Our Reference: **PT18022**

**Proposed Sikh Grammar School, Rouse Hill (SSD 9472)**  
**Addendum Traffic Report**

Further to our traffic impact assessment report dated November 2020 (PT18022r01\_Final\_V6), please find below some additional information in response to the matters raised by DPIE representatives following a preliminary assessment of the traffic impact assessment report.

CONSTRUCTION STAGE 4 - SITE PLAN
ESTIMATED COMPLETION JAN 2030

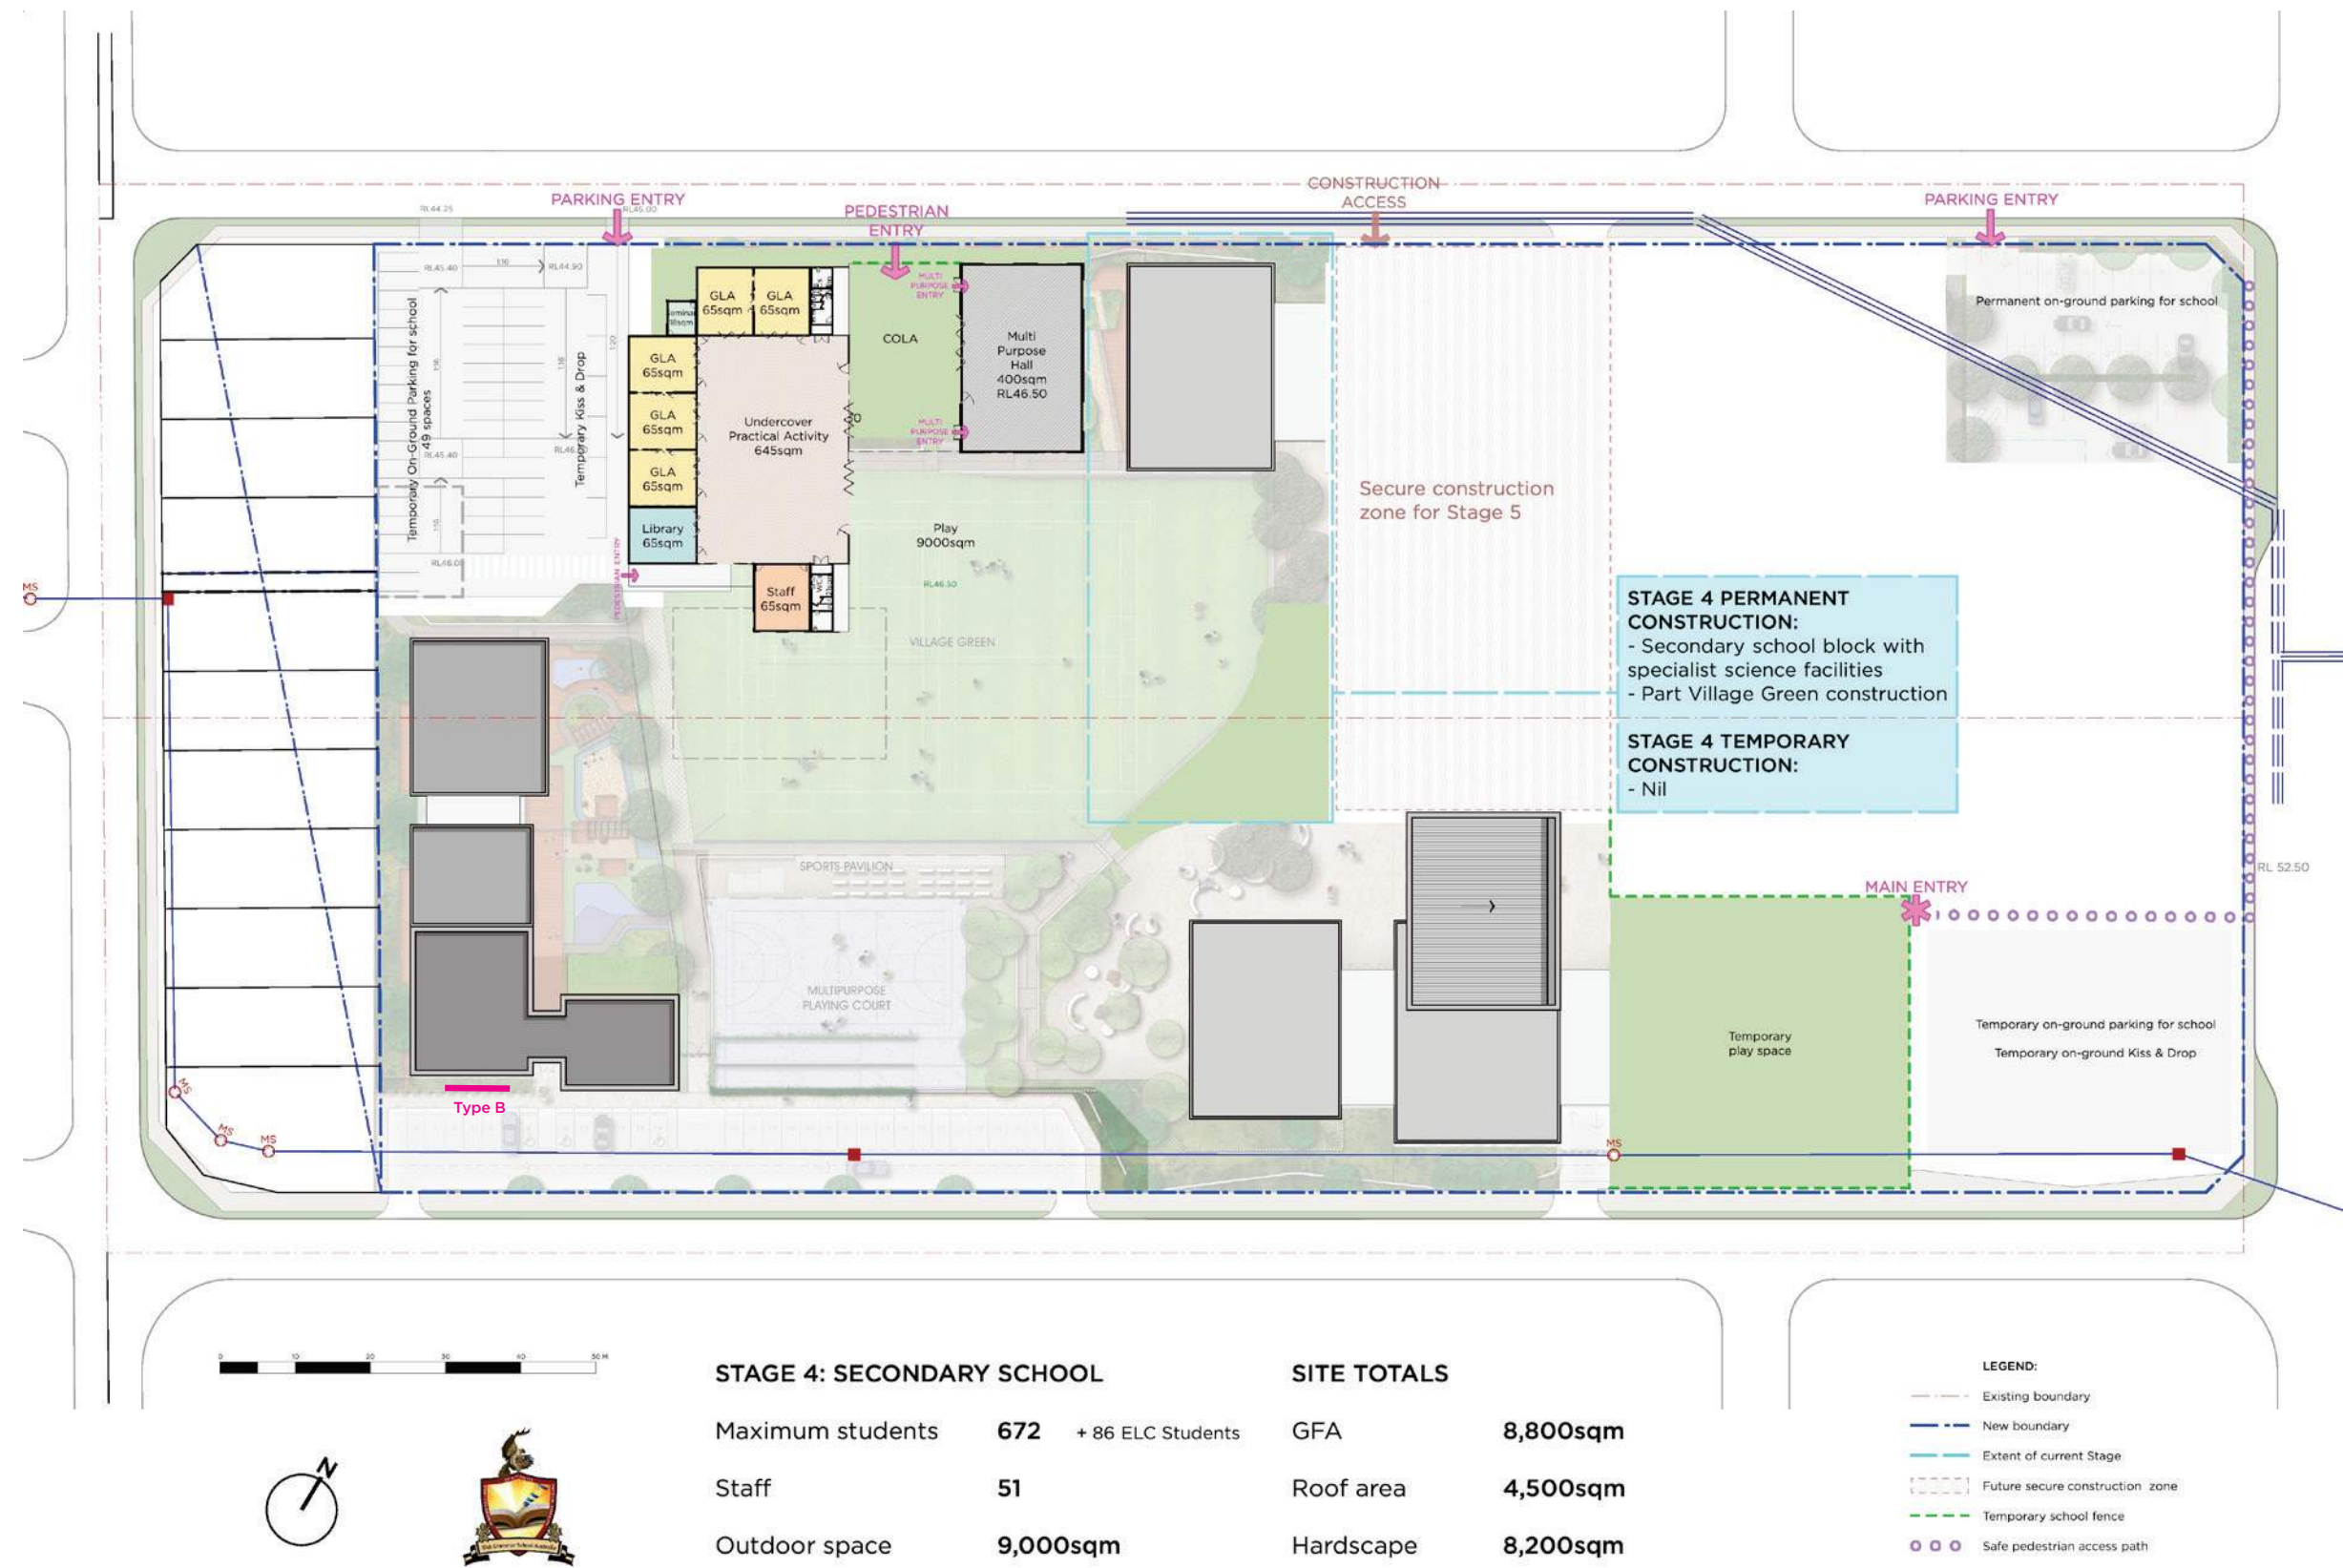
- ***the plan for Stage 4 shows an additional 40 on ground spaces and 10 drop-off / pick-up spaces at the south-eastern corner. This is not reflected in the traffic report.***
- ***the traffic report states that the under-ground drop-off / pick-up area would be delivered in Stage 5 whereas the Staging plan says it would occur in Stage 7.***

The revised staging plans presented in **Appendix A** of this response report should be considered as the most up to date information on the potential staging of the site.

To reflect the most current staging plans, **Table 3** in **Section 4.1** from the original traffic report has been updated to confirm the number of students, parking spaces, Kiss and Drop spaces and bicycle parking spaces identified to occur by stage and is presented below.
